Online Comment

Application H18-0671-19
Location 36 PETTS LANE SUTTON BRIDGE SPALDING PE12 9QB
Proposal Extension and alterations of existing house. Existing outbuilding to be converted into annexe and buildings linked together with a link building

Name Ian Marshman, Historic Environment Officer
Address Lincolnshire County Council Lancaster House 36 Orchard Street LN1 1XX

Date Submitted 01-08-19
For/Against Comments

PROPOSED HOUSE PLANS

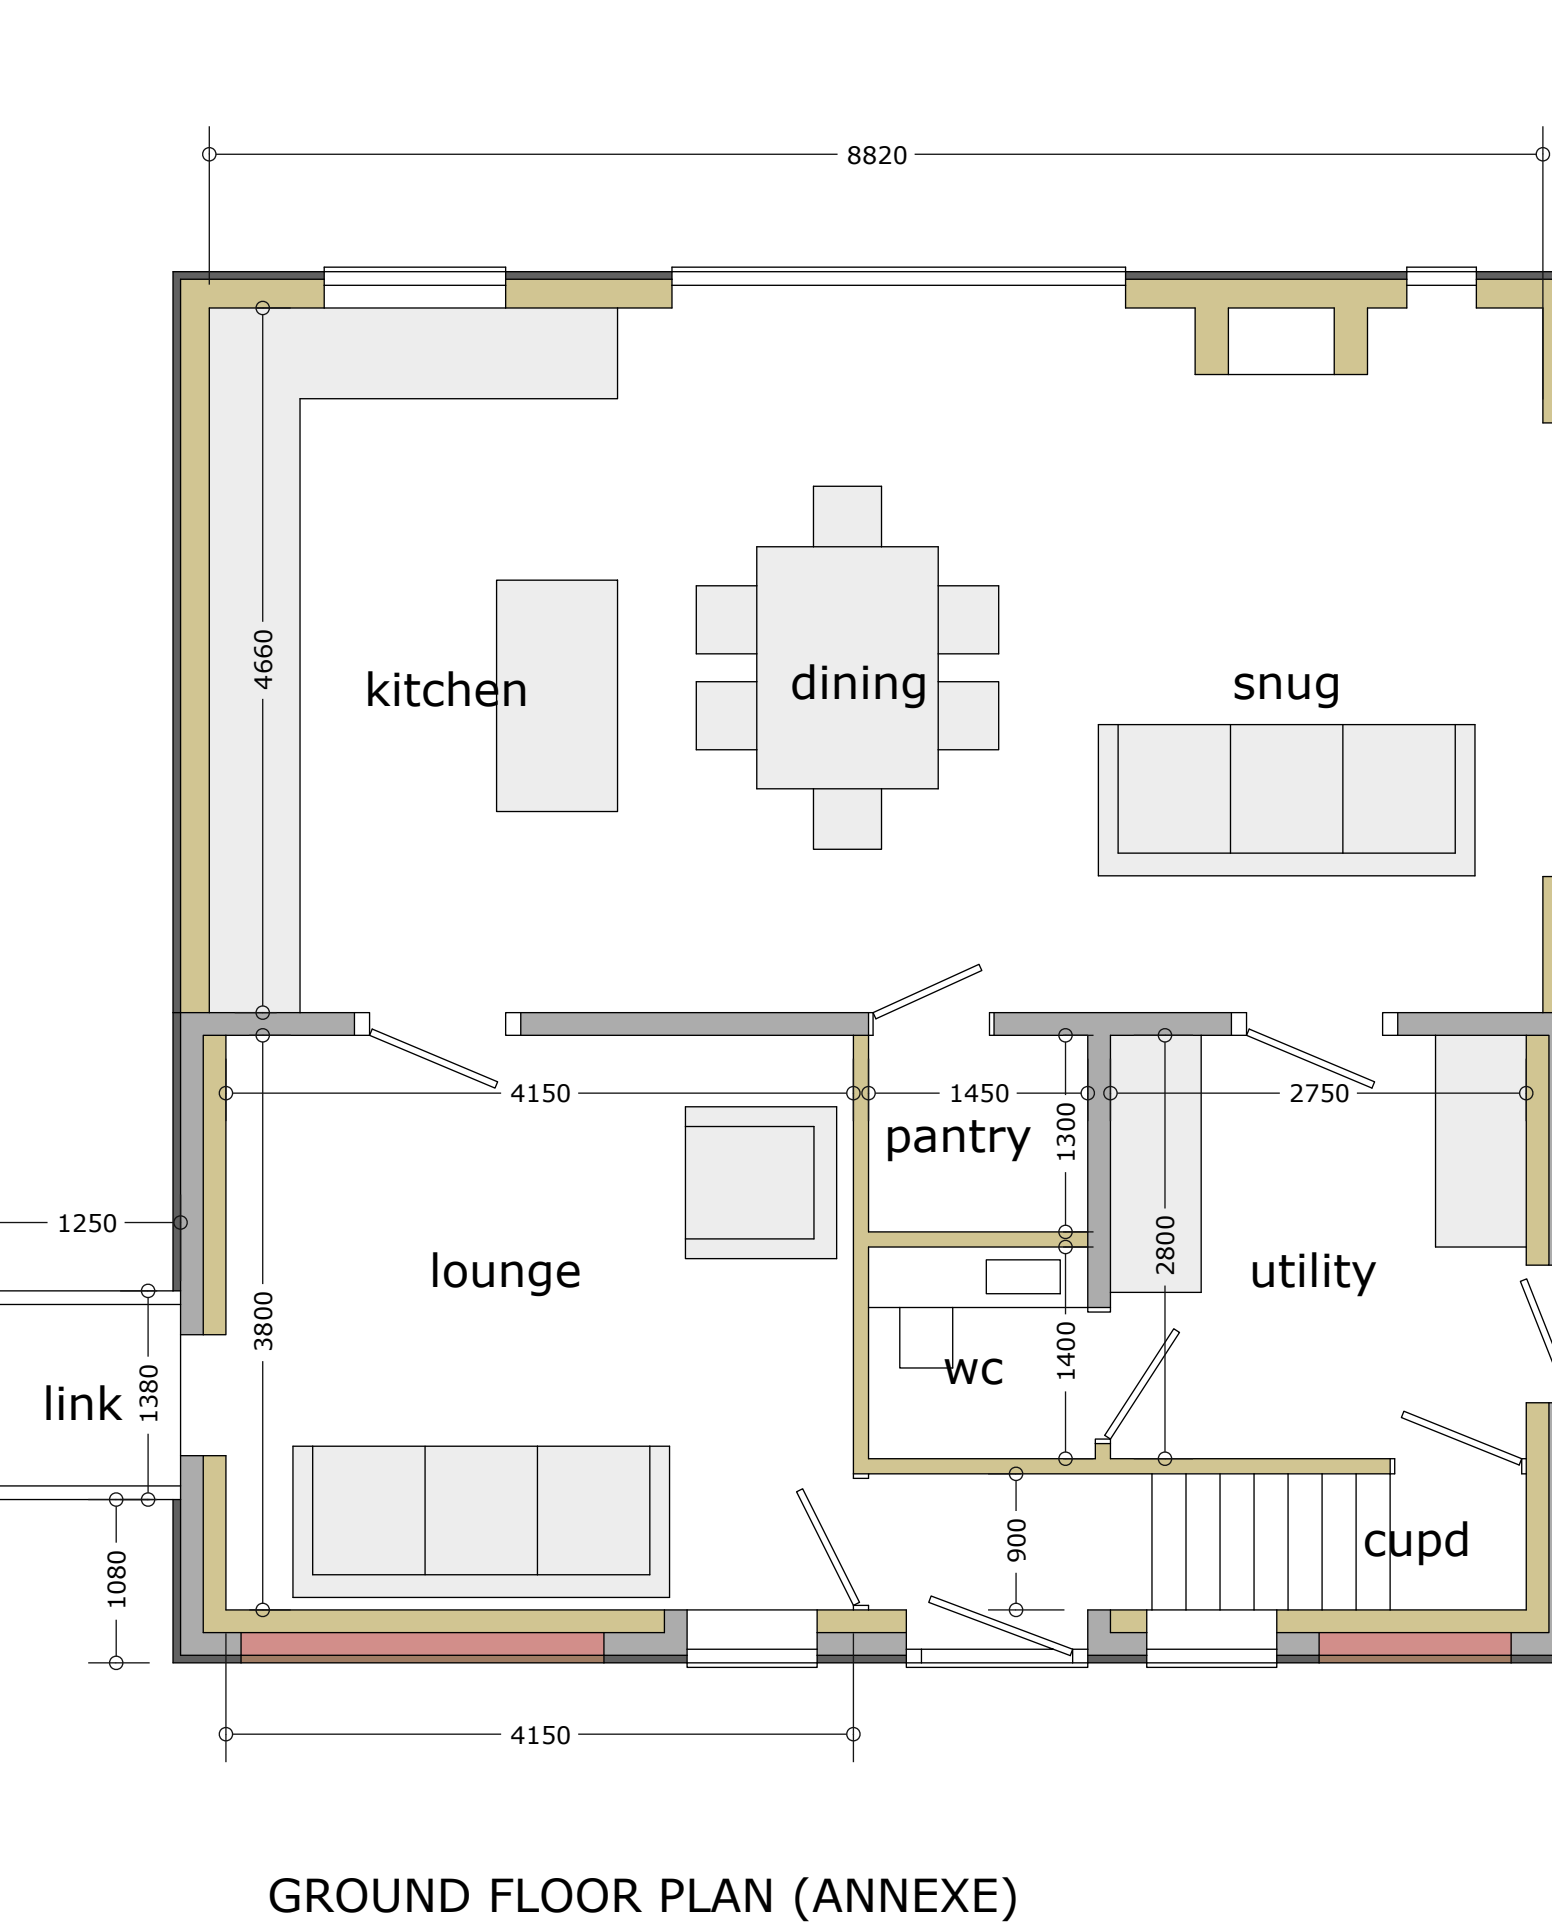
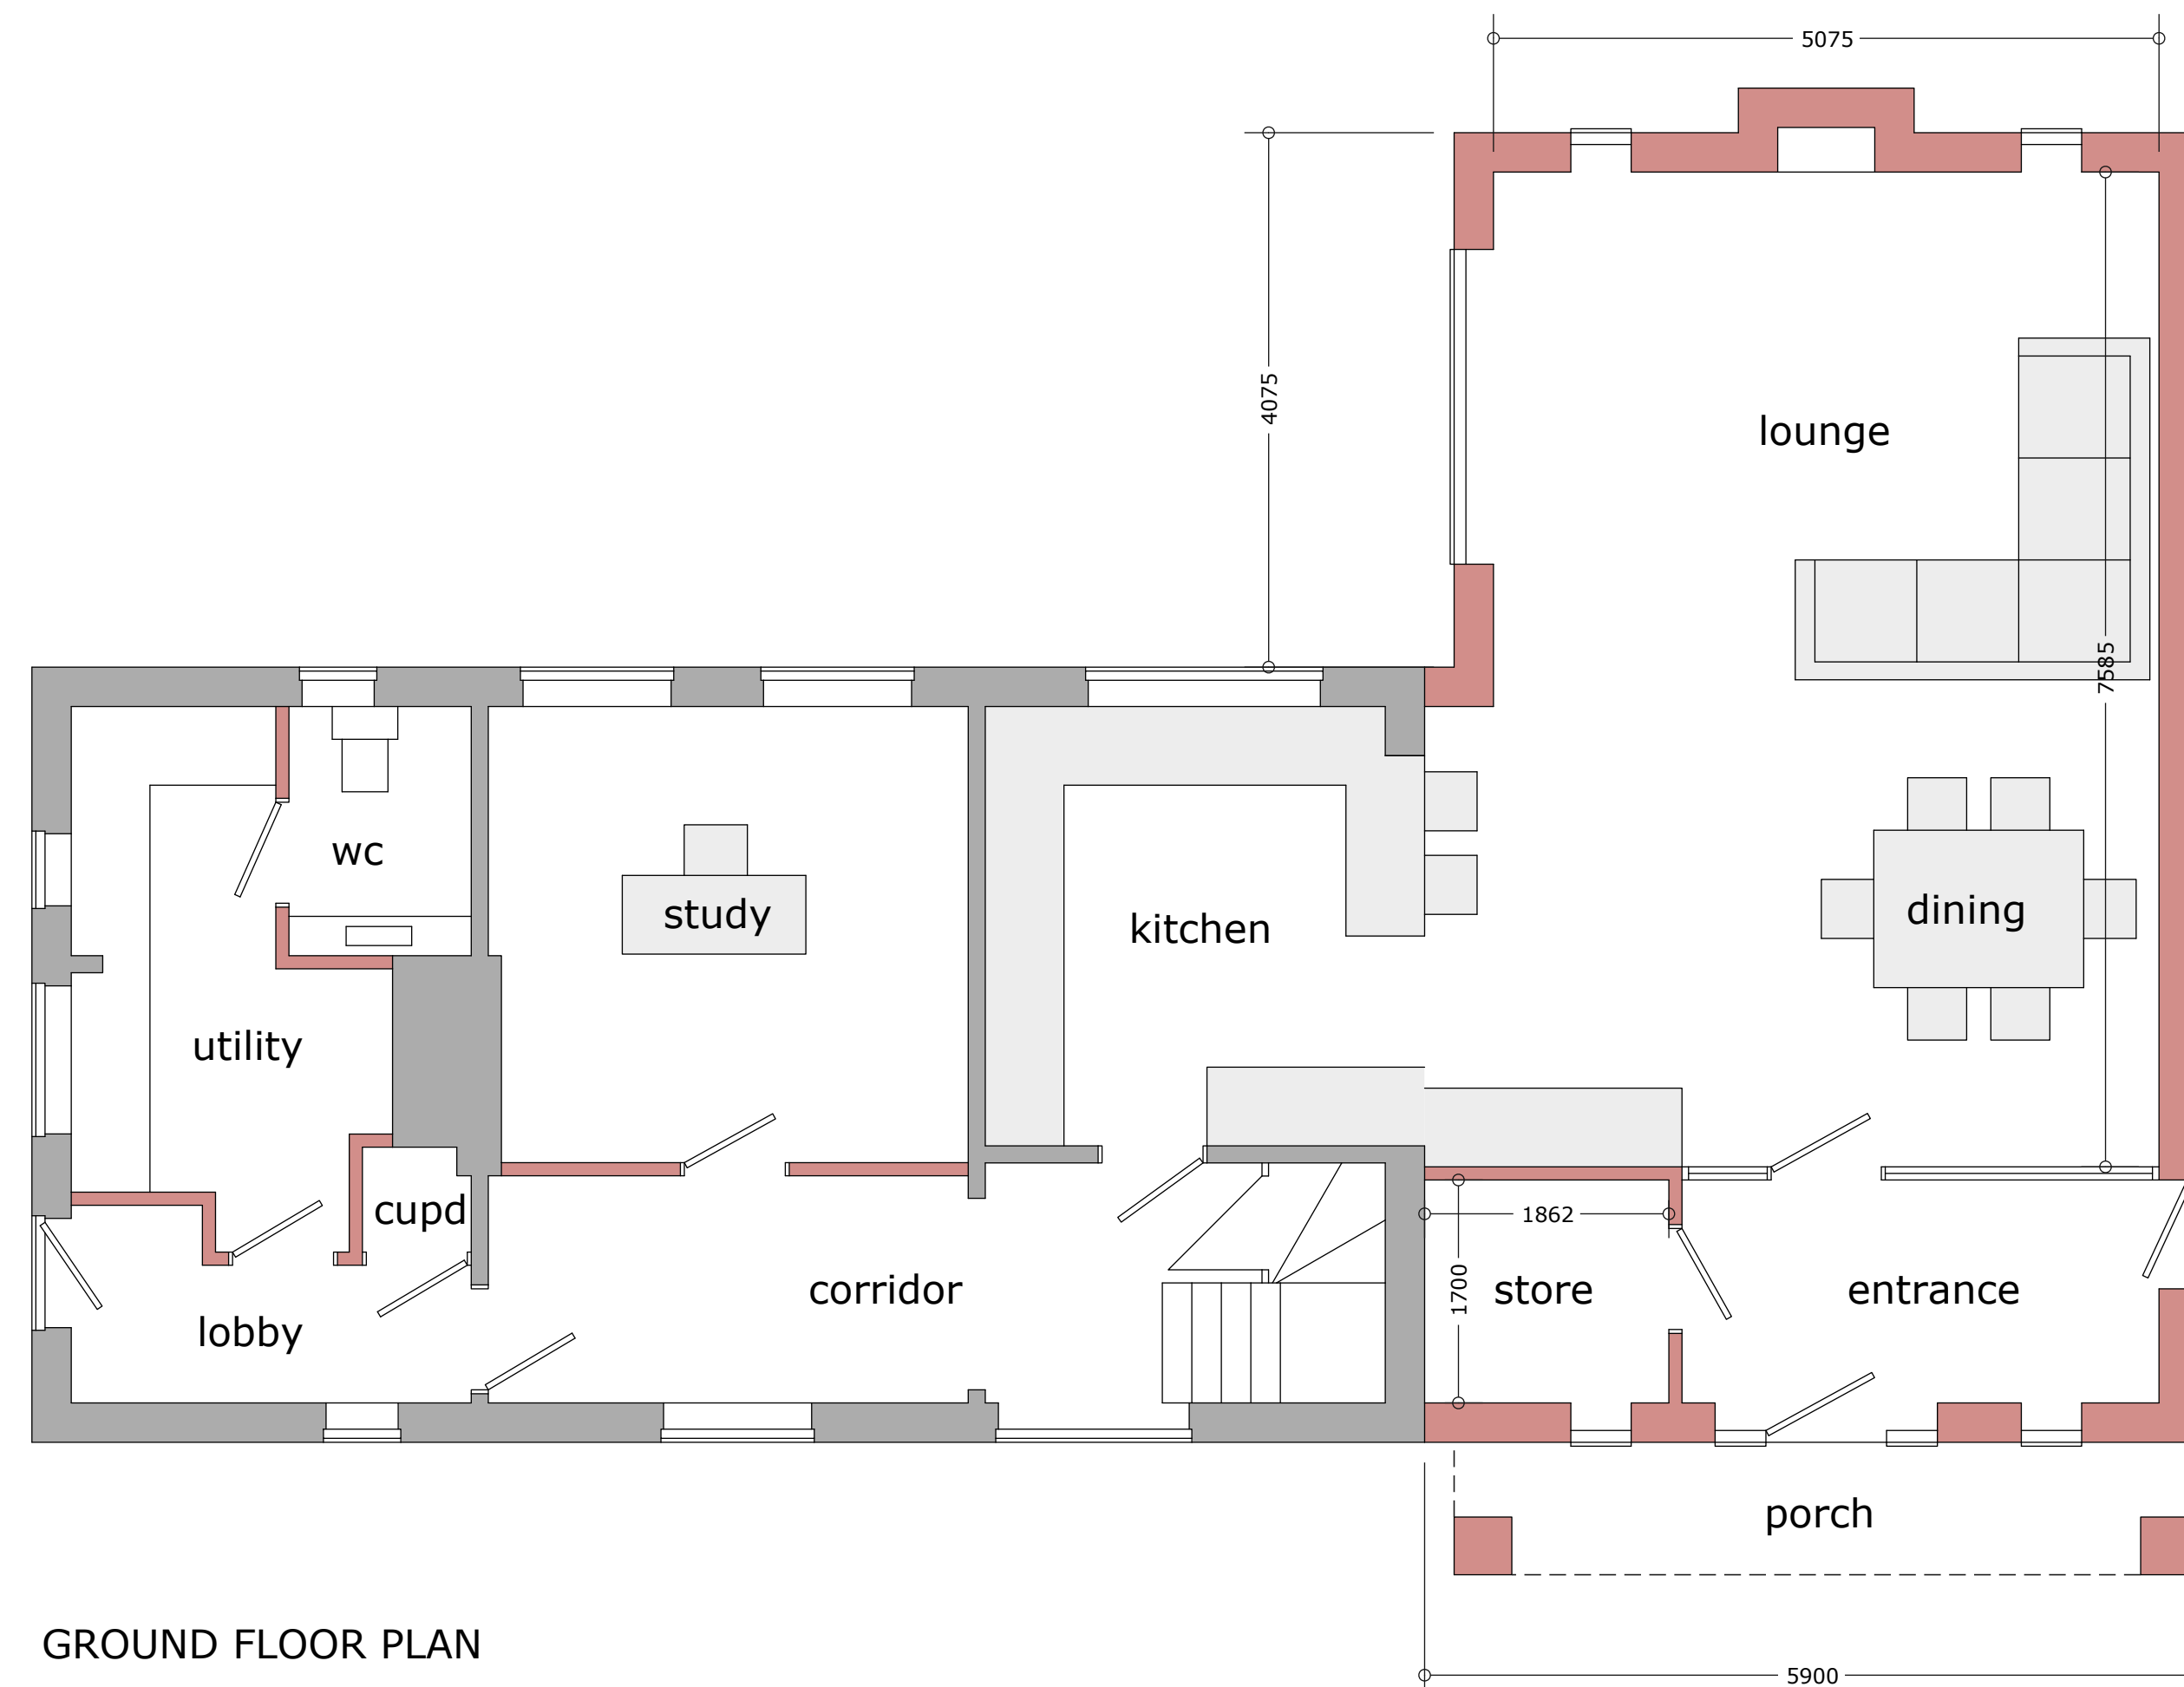
The present proposals involve the conversion of the original barn from the small holding, and a substantial new extension in the form of a projecting wing of modern design, as well as reordering and replacement of windows and doors, and the removal of one of the pair of chimneys on the original cottage. This would result in the new extension dominating the historic cottage and smallholding, to the extent that its historic character would no longer be legible, leading to an almost total loss of significance.

Cumulatively these alterations and the new render would result in the cottage taking on the appearance of a single wing of a new build executive home, which reflects neither the site's heritage, agricultural character or rural location. This is not in accordance with Policy 29 of the South East Lincolnshire Local Plan:

It is recommended that the developer work with the district's Conservation Officer to amend the proposals to better preserve the building's significance, and ensure that the new extension is sensitive to the design, detailing and setting of its historic host dwelling.
